MEMORANDUM

Date: August 22, 2016

Re: *Comments on SEP16-015*
Comments on ZTR16-002
Location of the Property: Southwest corner of 77th Avenue SE and SE 32nd Street,
Mercer Island, WA 98040

MERCER ISLAND CENTER FOR THE ARTS CONCEPTUAL MITIGATION PLAN

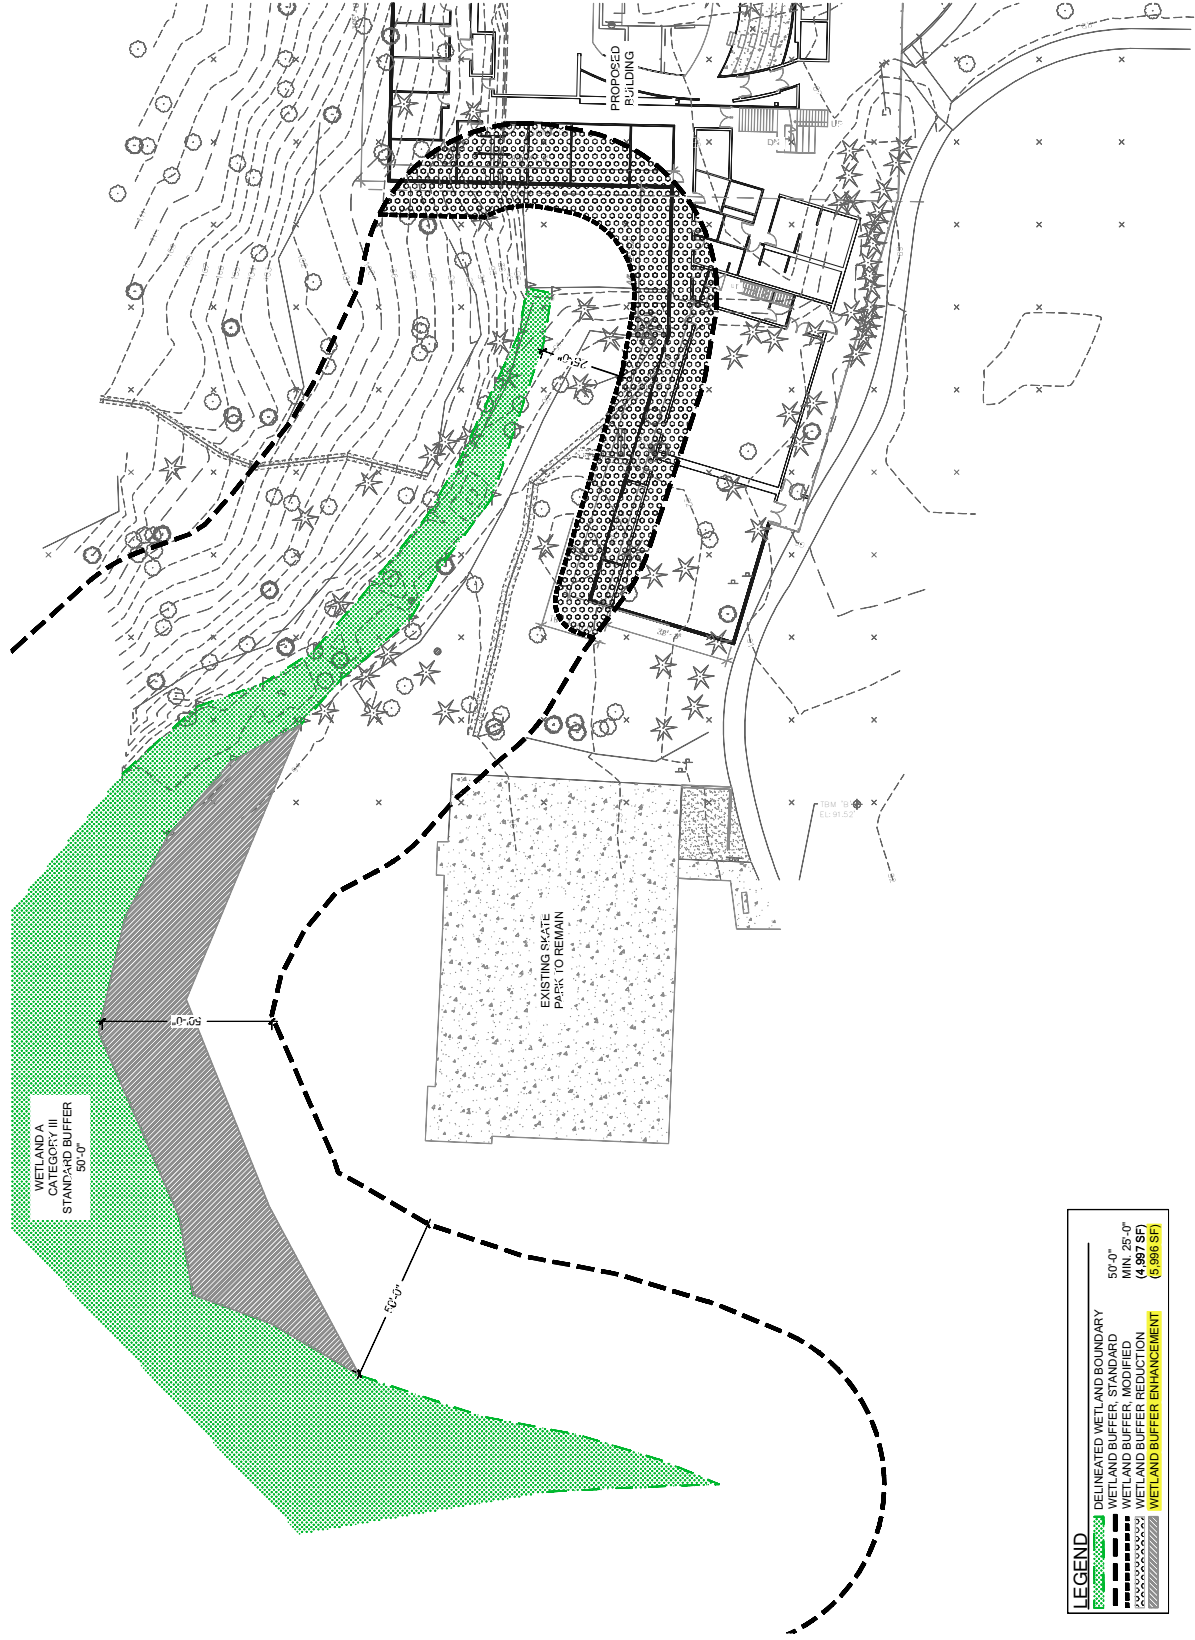
To date, there is no critical area study and the above three separate elements have not been satisfied. More specifically, there is no showing of zero net loss of buffer function. It strains scientific credulity to believe that building on top of the current buffer will not result in reduction of buffer function.

Attachment L
Site & Paving Plan

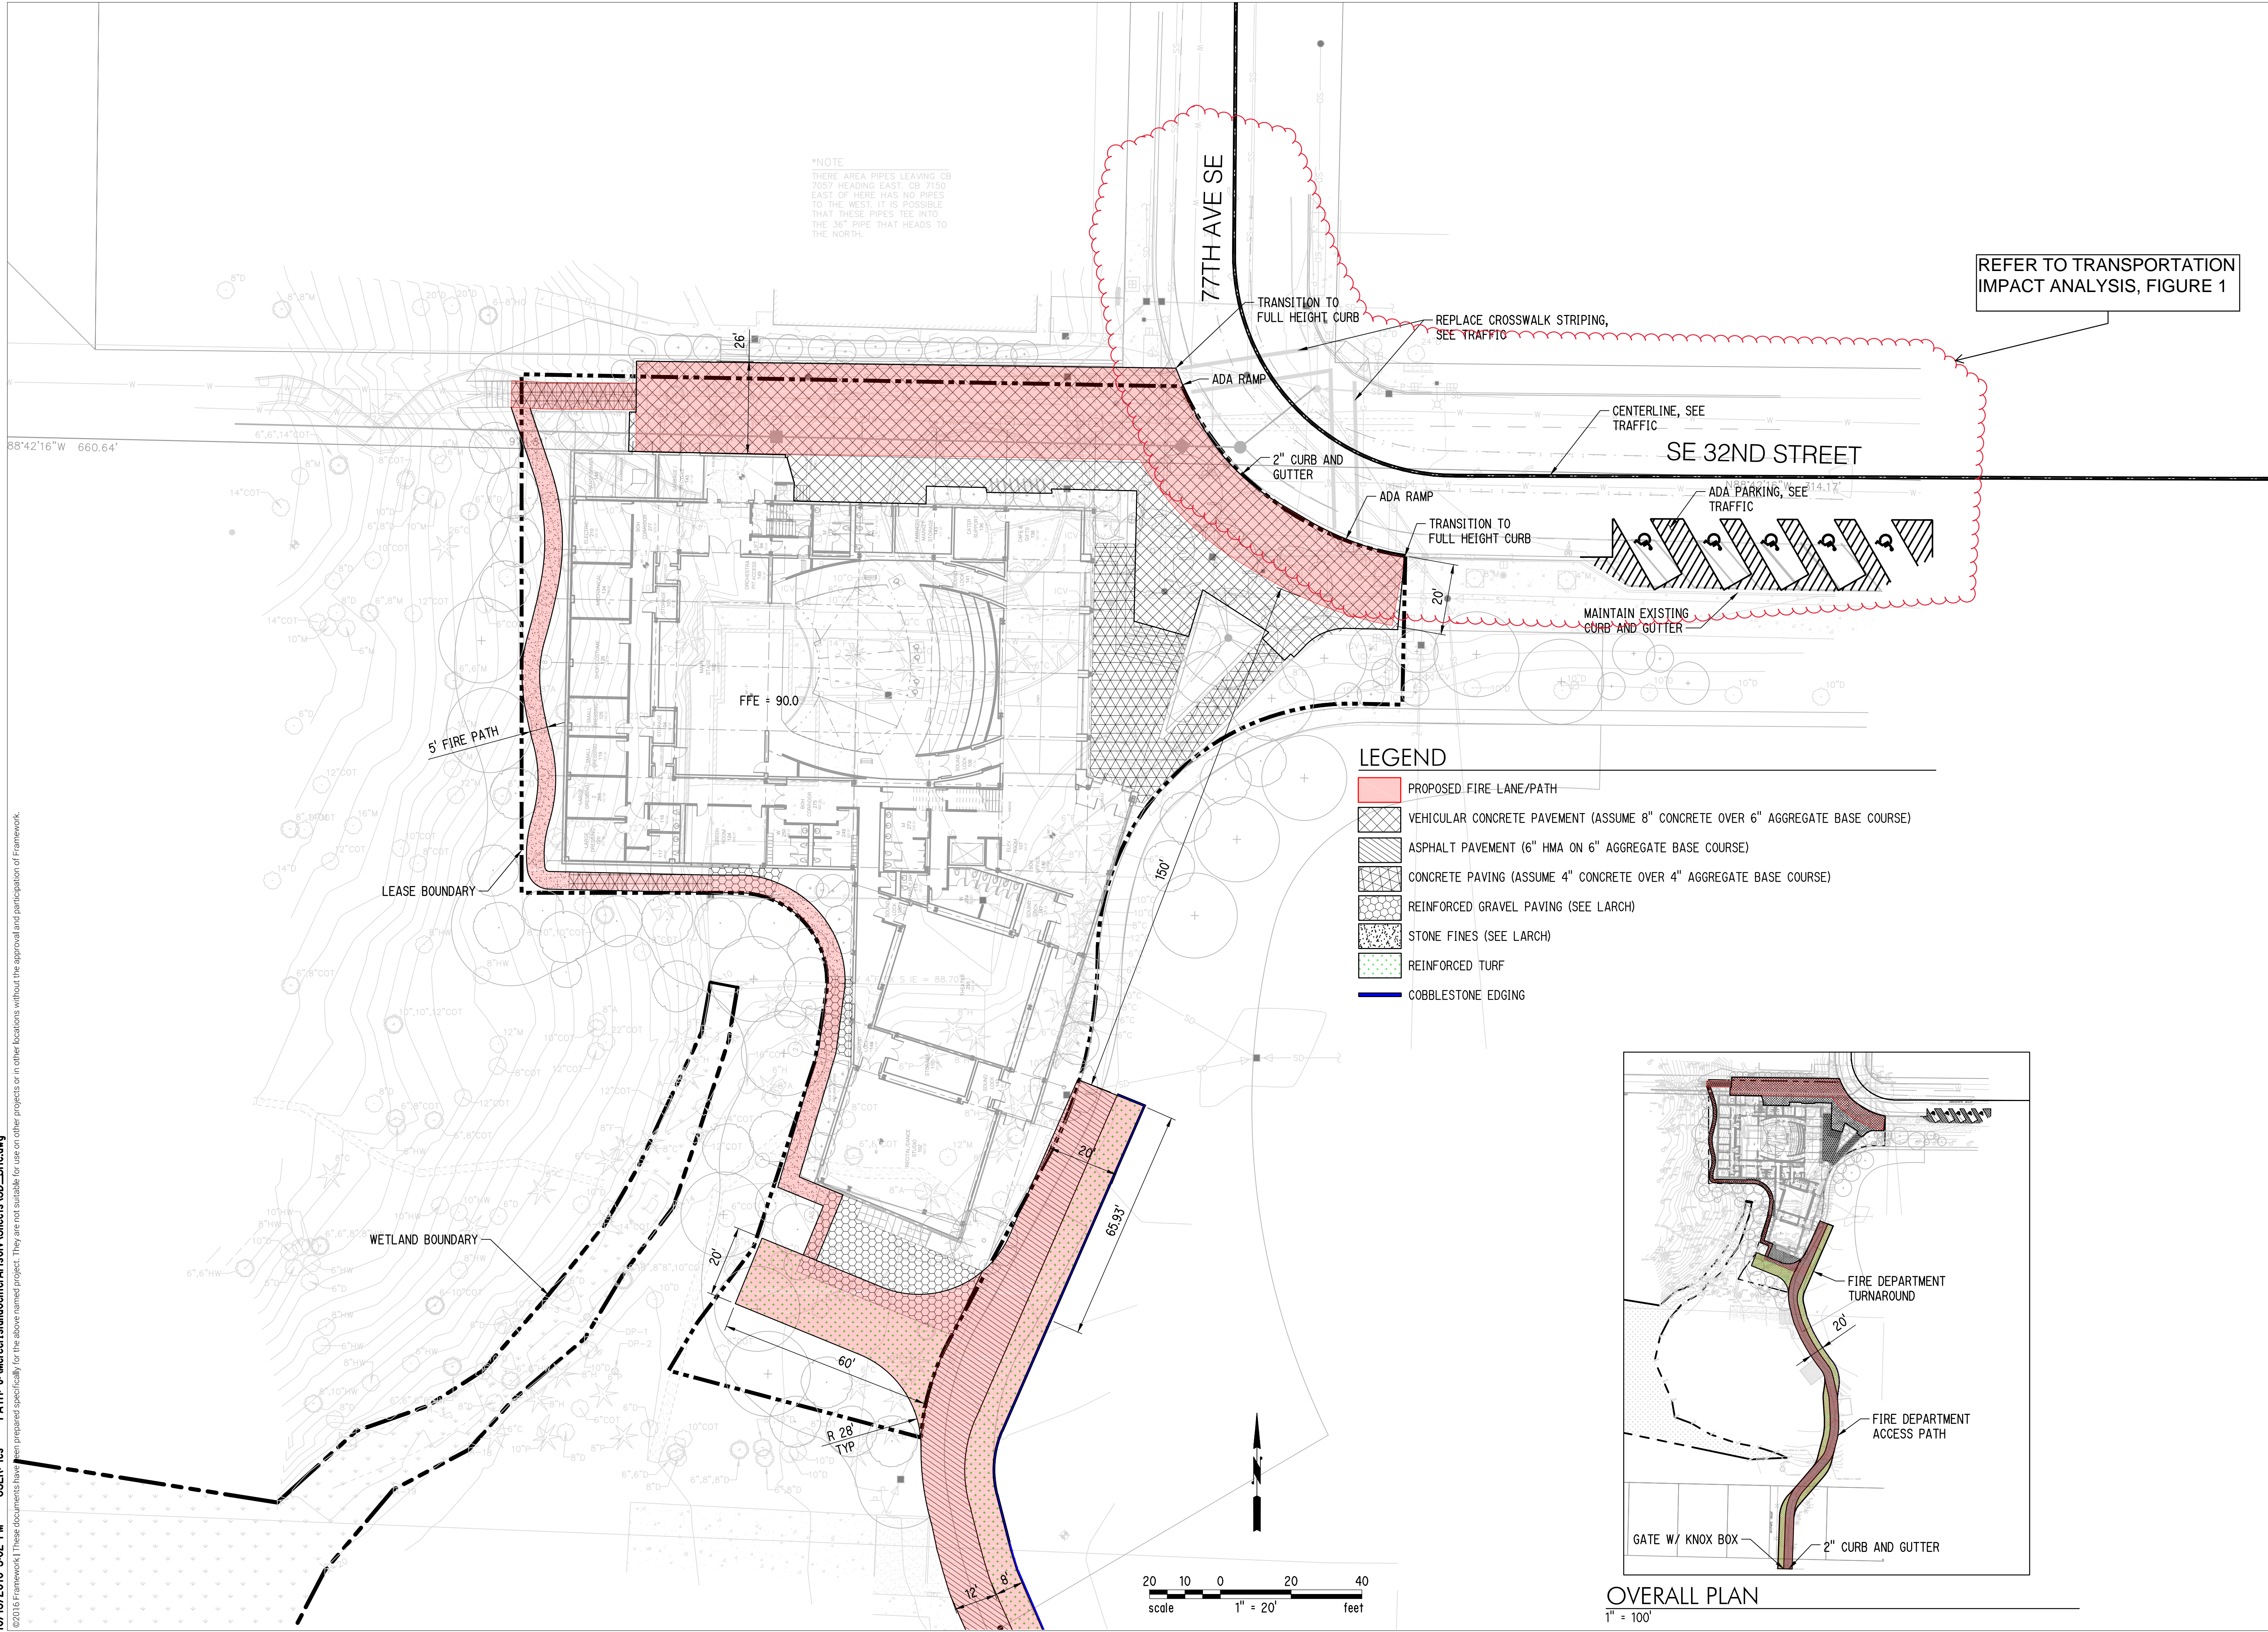
4. Water Runoff
 - a. The SEPA Checklist § B, Q. 3 subsection c(1) contemplates a bioretention area, an underground stormwater detention vault and related drains *outside* of the lease boundaries. *See* SEPA Checklist Attachment M. There is no authority for MICA to build necessary building elements on city land without a lease for that specific area.
 - b. The SEPA Checklist § B, Q. 3 subsection d contemplates a “proposed swale that will be strategically graded into the hillside” *outside* of the lease boundaries. *See* SEPA Checklist Attachment B. There is no authority for MICA to build necessary building elements on city land without a lease for that specific area.

SHORT PLAT

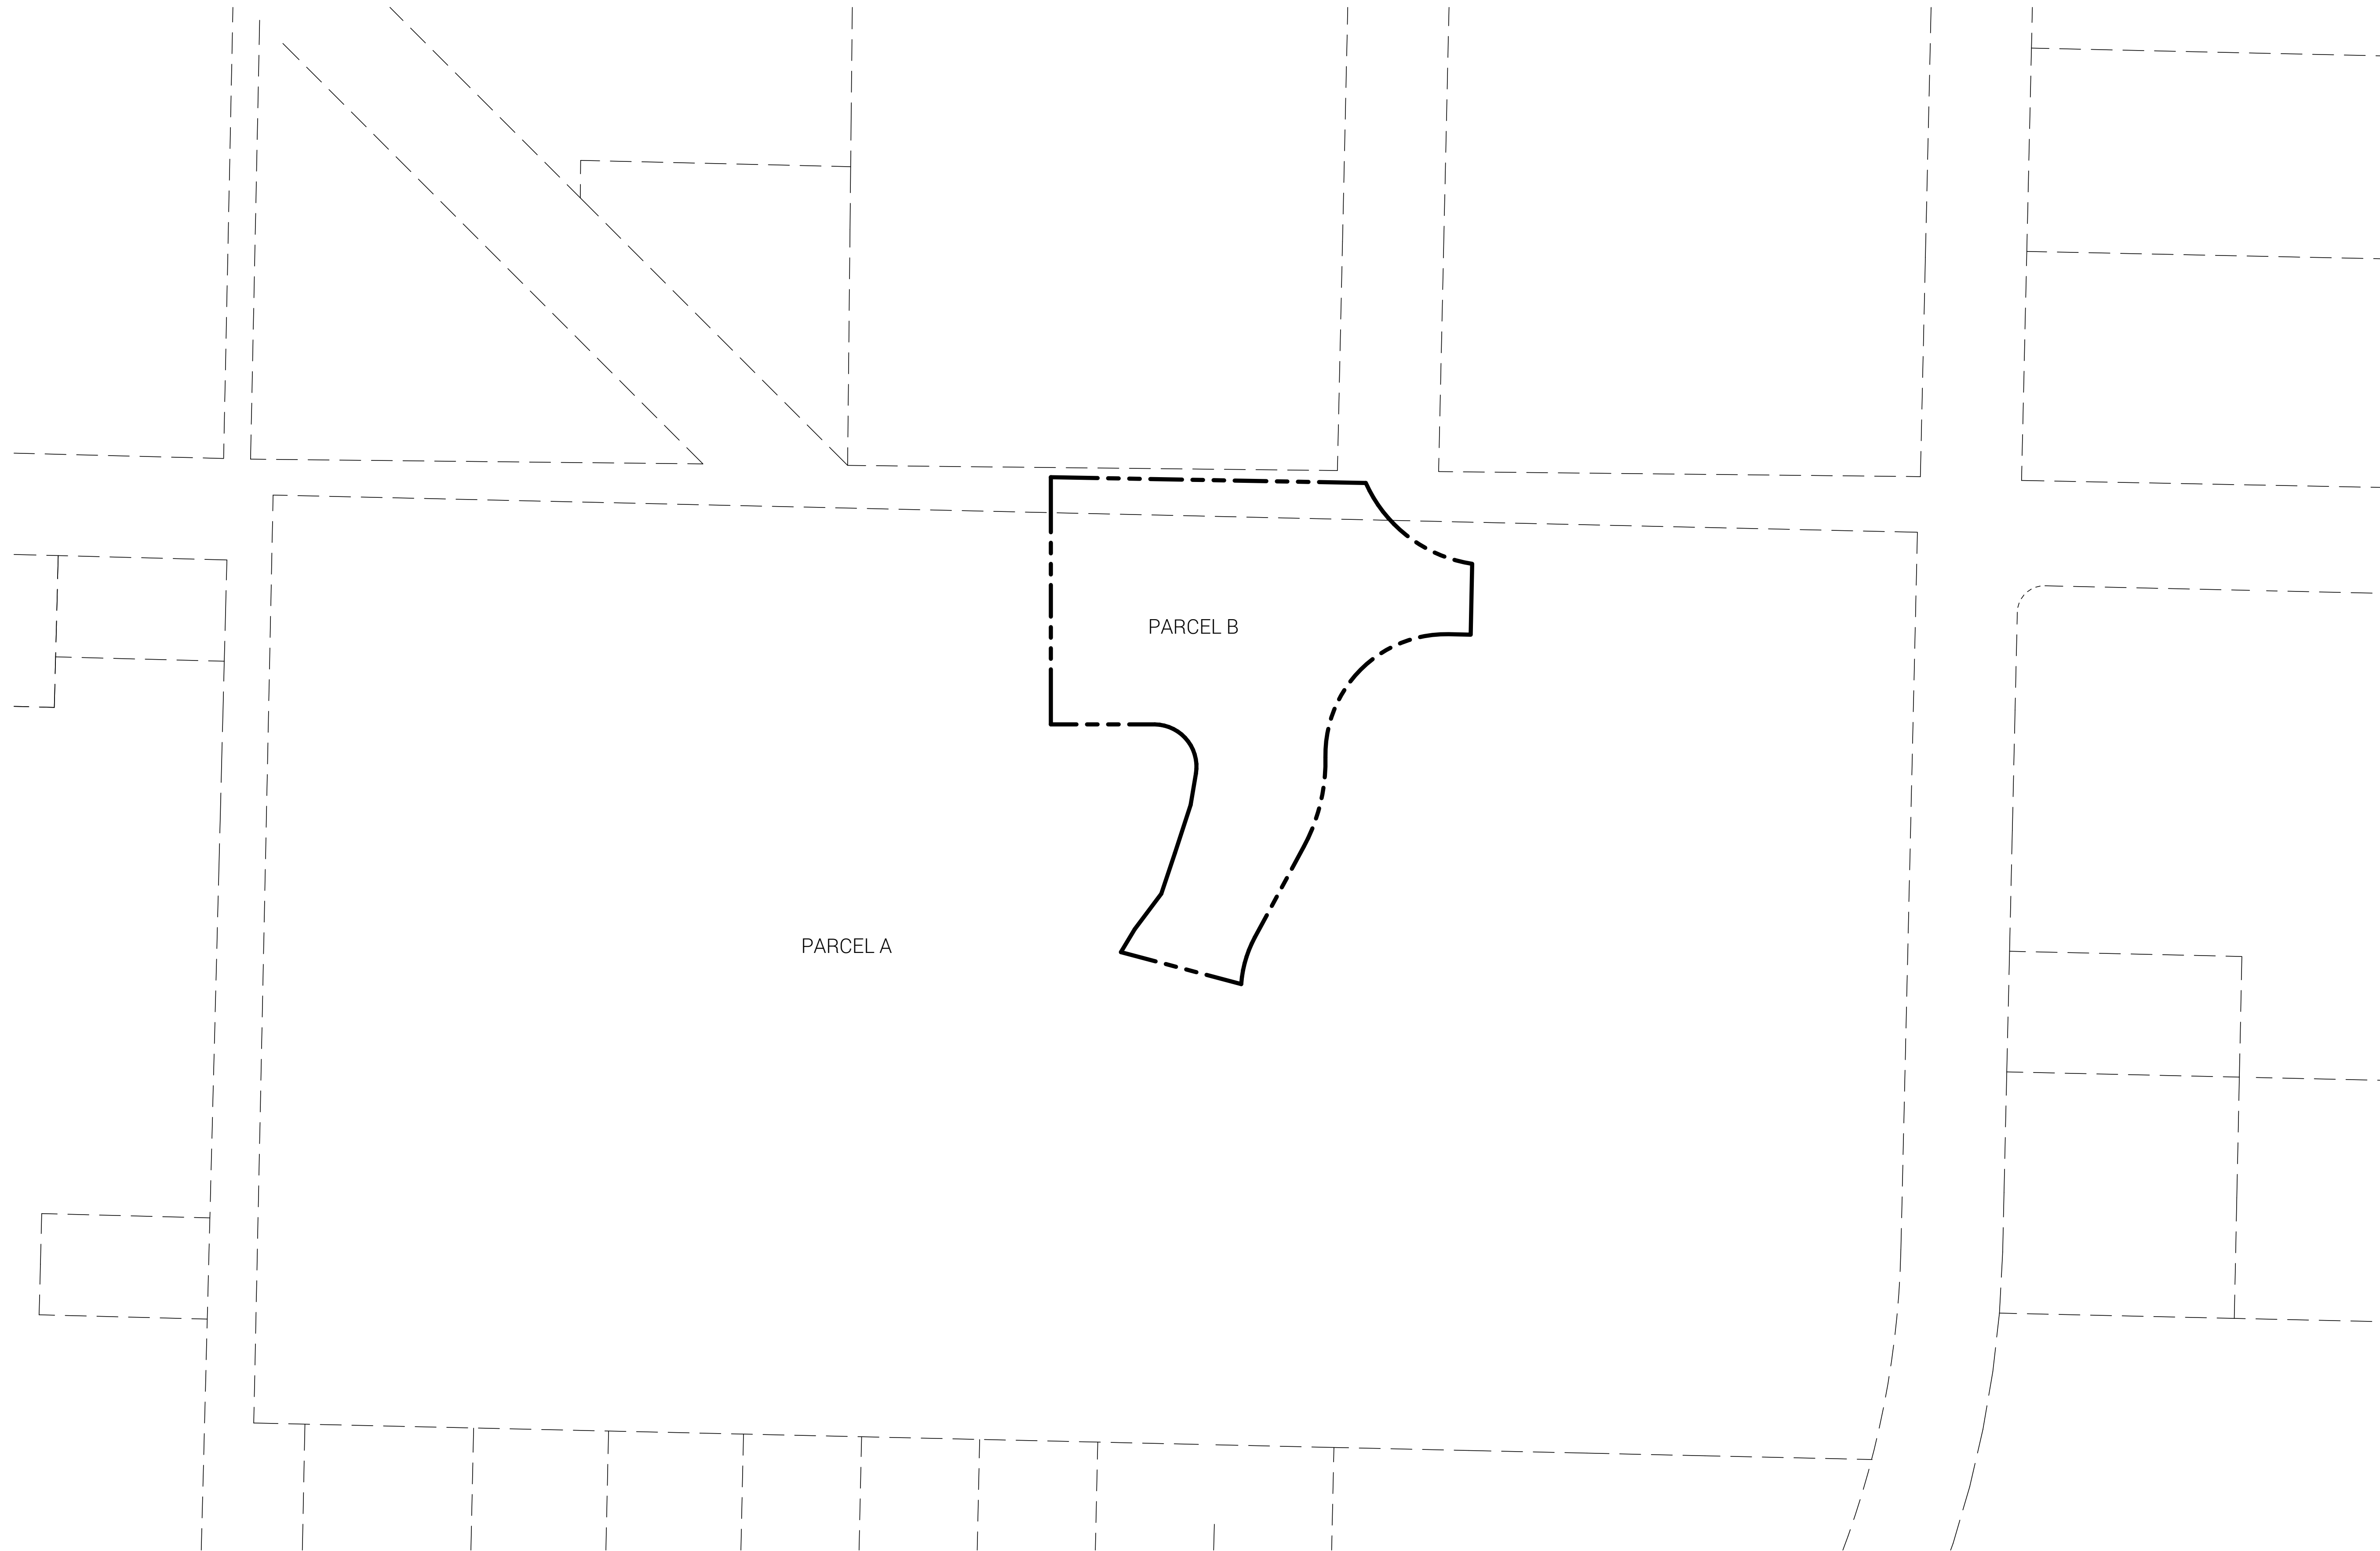
1. Proposed timing or schedule
 - a. The July 18, 2016 letter from Mercer Island Development Services Group Director, Scott Greenberg, to Lesley Bain specifically requests that MICA “modify the submitted SEPA Checklist to include a short subdivision (short plat) as part of the project.
 - b. The SEPA Checklist § A, Q. 6 does not explicitly contemplate a short plat but rather states “a possible Short Plat if required by the City”.
